Re: Letter of Concern 3 regarding Kittitas County Conditional Use Application CU-23-00001

QUESTIONS AND CONCERNS REGARDING KITTITAS COUNTY CU-23-00001

Re: Addendum #1 to 3-8-2023 Letter of Concern regarding Conditional Use Application CU-23-00001, [CU-23-00001 - 3 BR Custom Cuts - Comments Matthew Vaughan, Arrienne & Shannon Bright 3-8-23](#)

Re: Letter of Concern regarding Conditional Use Application CU-23-00001

Drawing file: CU-23-00001 3 BR Custom Cuts / CU-23-00001 3 BR Custom Cuts - Site Plan (REVISED APPLICATION) 4-4-23.pdf

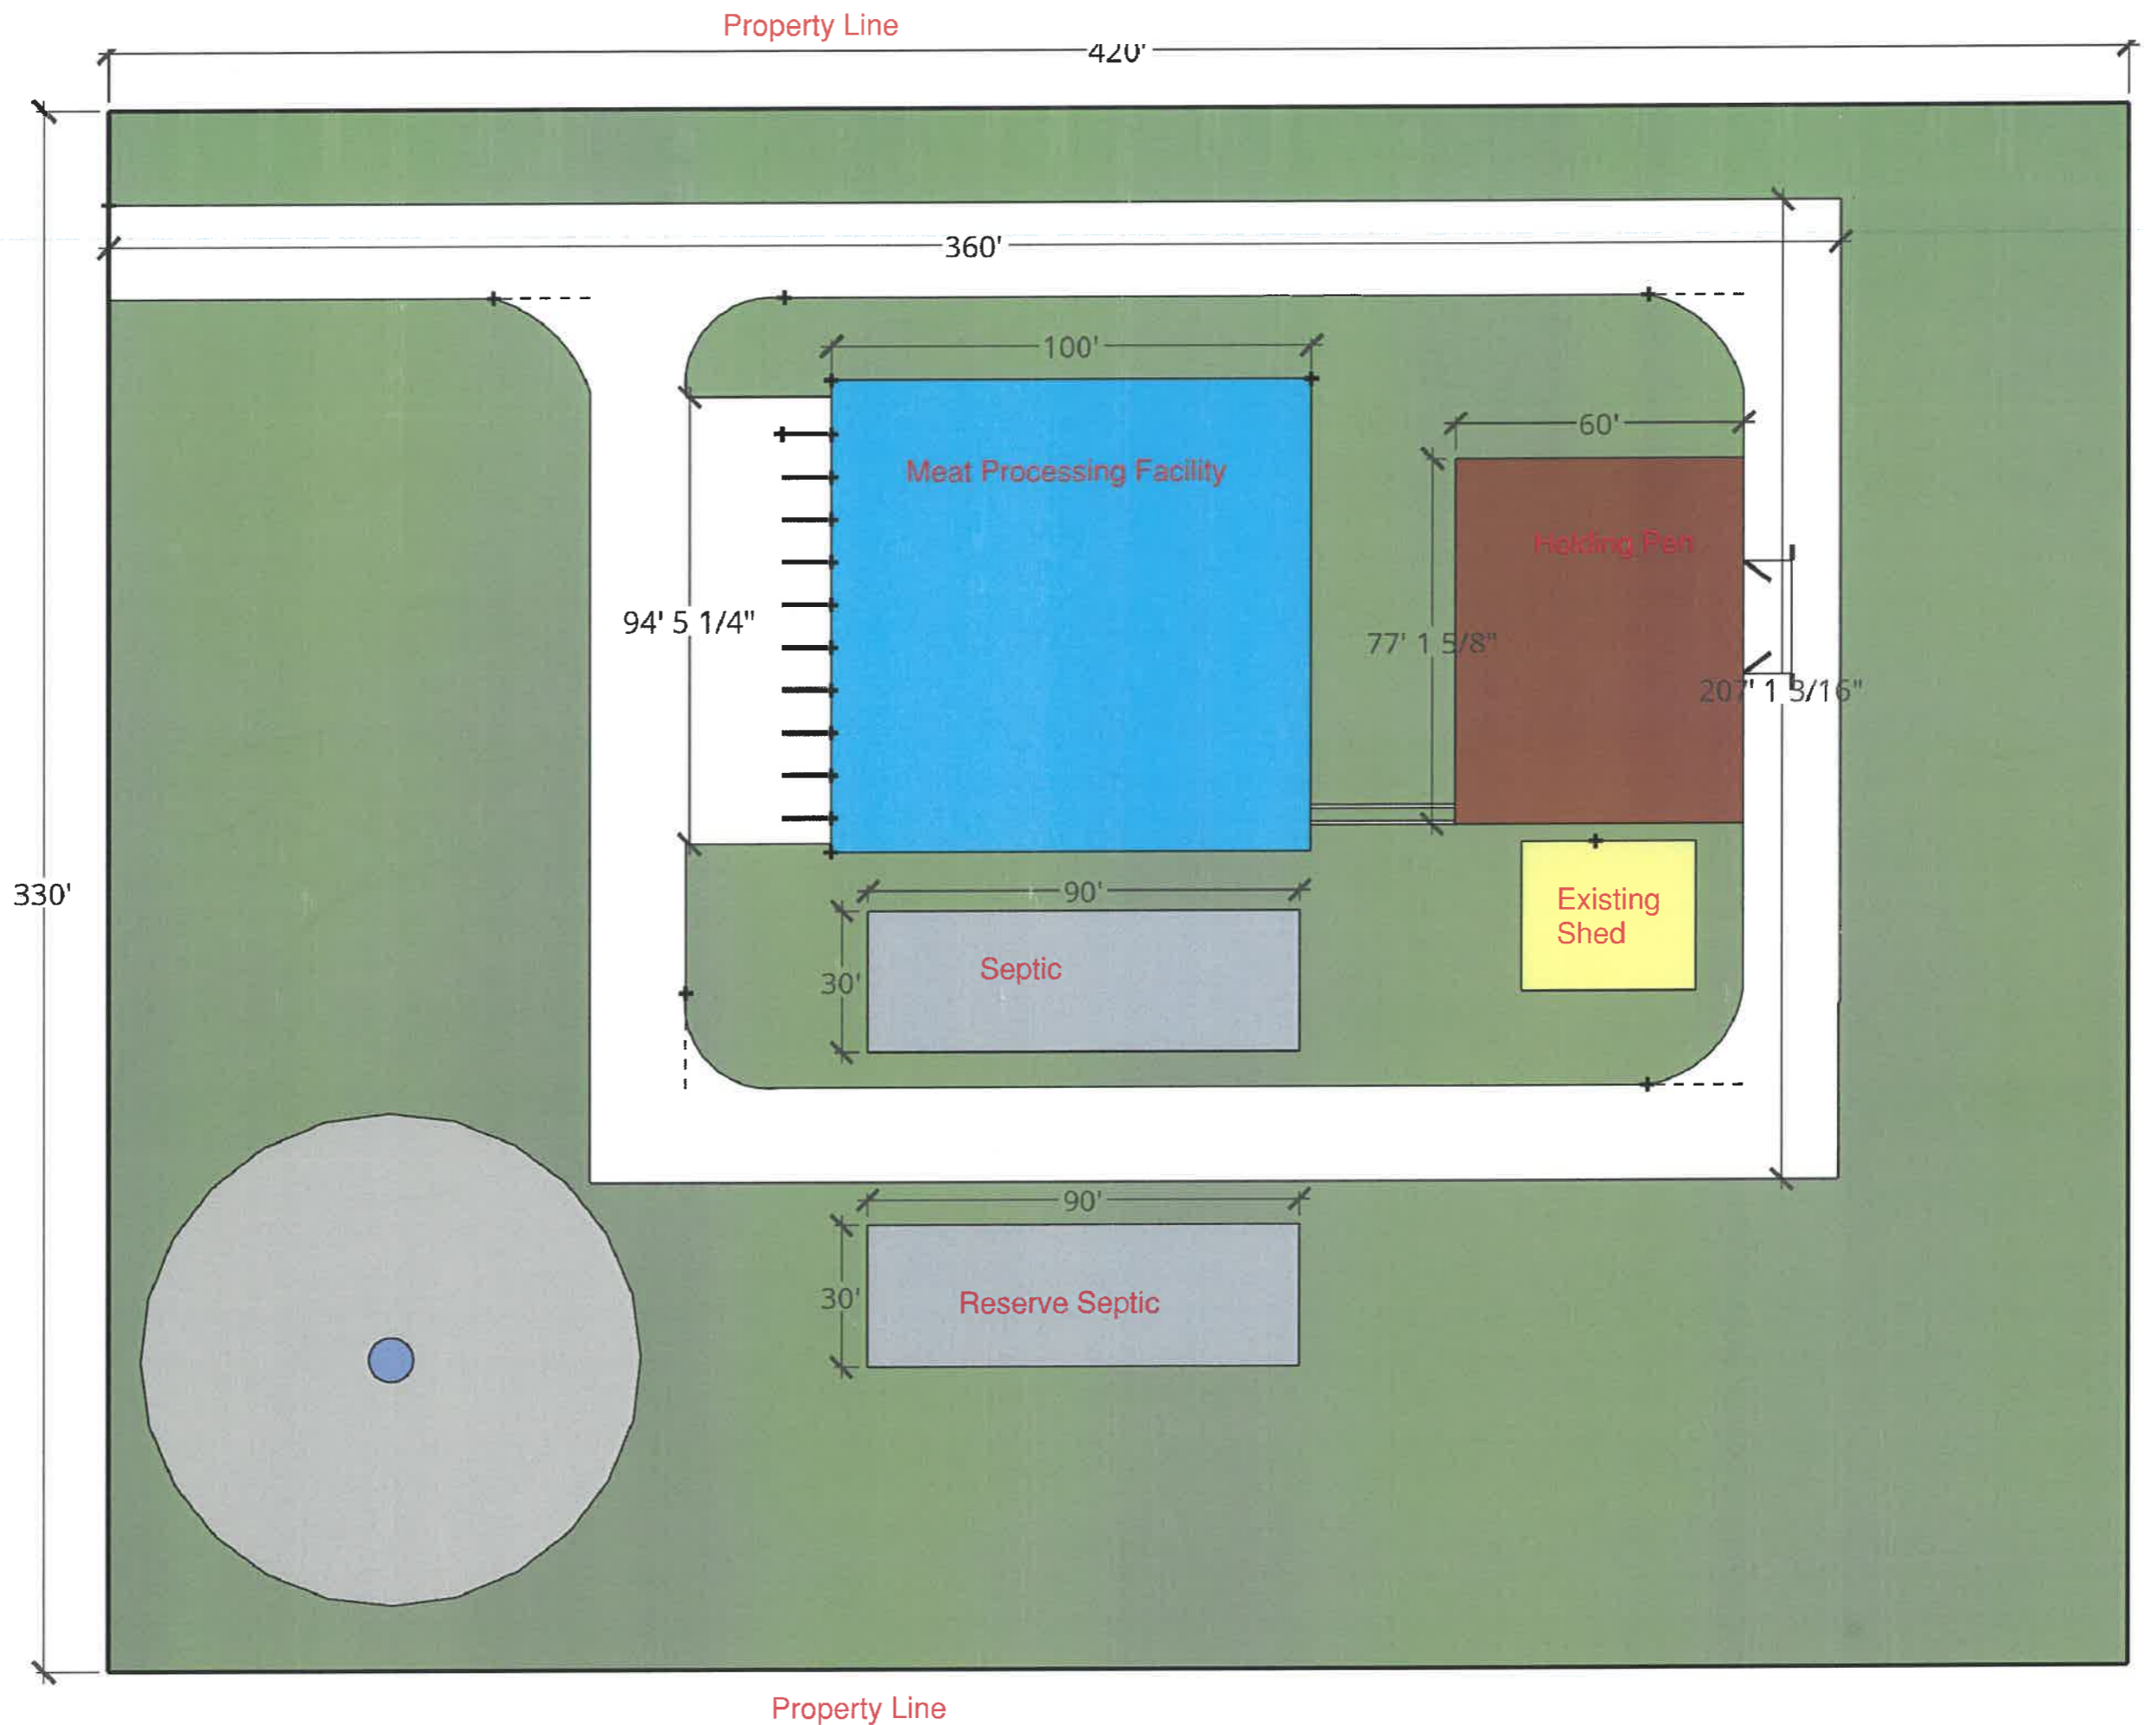
Wilson Creek is a 50mph zone adjacent to this site. A modest sized stock trailer is forced to enter and block oncoming traffic to make a right angle turn as noted in the site plan included within this reapplication posing a public safety hazard.
